From: Nicola Moore on behalf of Planning.Responses
Sent: 22 July 2019 14:22
To: Planning Scanning
Subject: FW: Planning Consultation on: WA/63/19/PL

Engineers Comments Regarding Surface Water Drainage

APPLICATION NO: WA/63/19/PL

Site Address: Land South of Arundel Road Walberton BN18 0QP

Granular Filled Soakaway Details

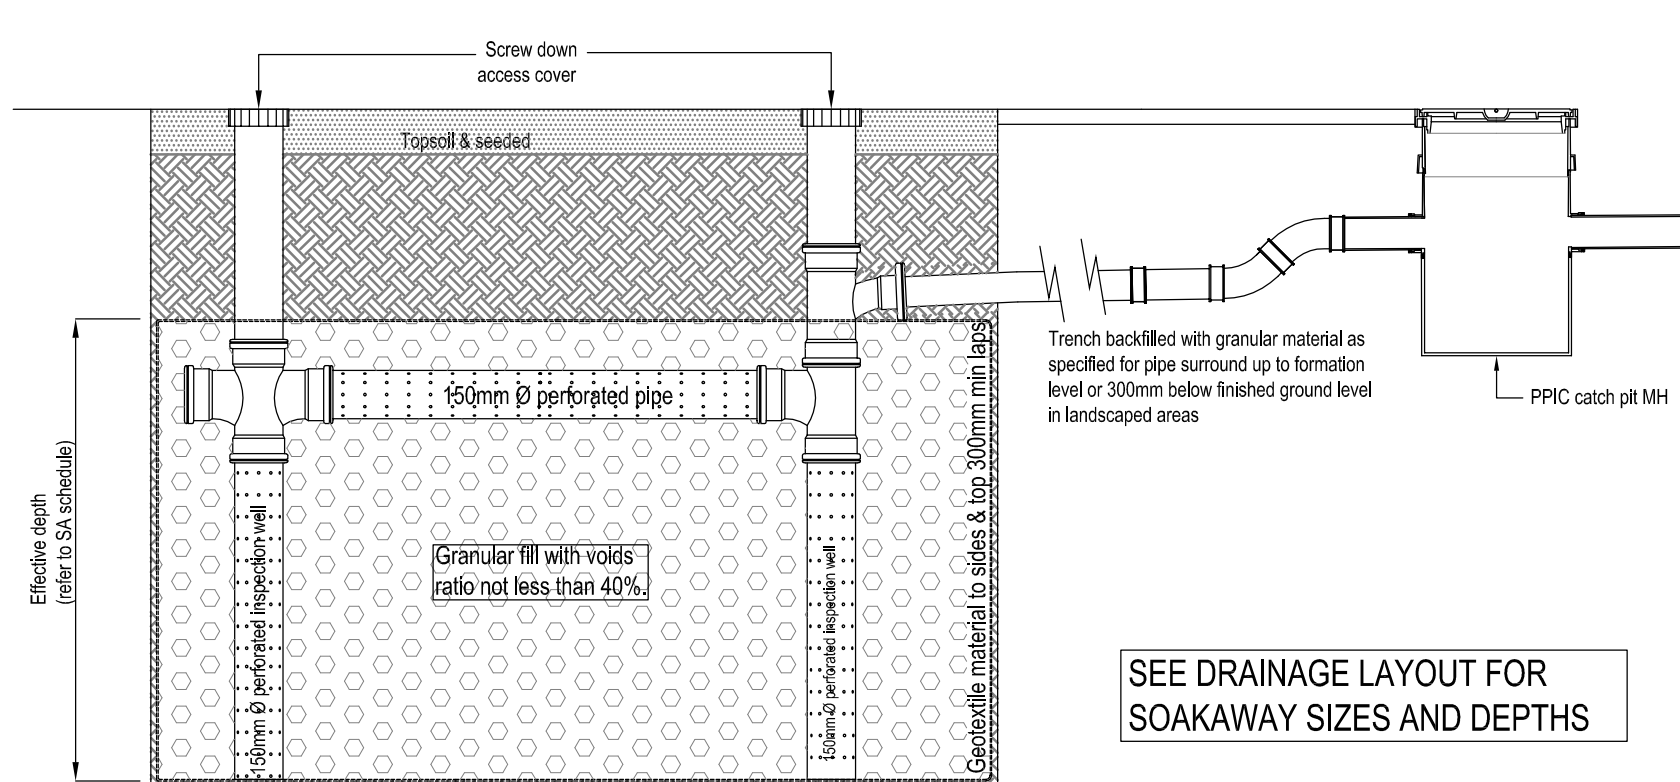
A drainage strategy has been submitted demonstrating that infiltration should work on this site. Winter groundwater monitoring and infiltration testing has been completed. The exact location of soakaways will need to be reviewed against root protection areas.

"Infiltration rates for soakage structures are to be based on percolation tests undertaken in the winter period and at the location and depth of the proposed structures. The percolation tests must be carried out in accordance with BRE365, CIRIA R156 or a similar approved method and cater for the 1 in 10 year storm between the invert of the entry pipe to the soakaway, and the base of the structure. It must also have provision to ensure that there is capacity in the system to contain below ground level the 1 in 100 year event plus 40% on stored volumes, as an allowance for climate change. Adequate freeboard must be provided between the base of the soakaway structure and the highest recorded annual groundwater level identified in that location. Any SuDS or soakaway design must include adequate groundwater monitoring data to determine the highest winter groundwater table in support of the design. The applicant is advised to discuss the extent of groundwater monitoring with the Council's Engineers.
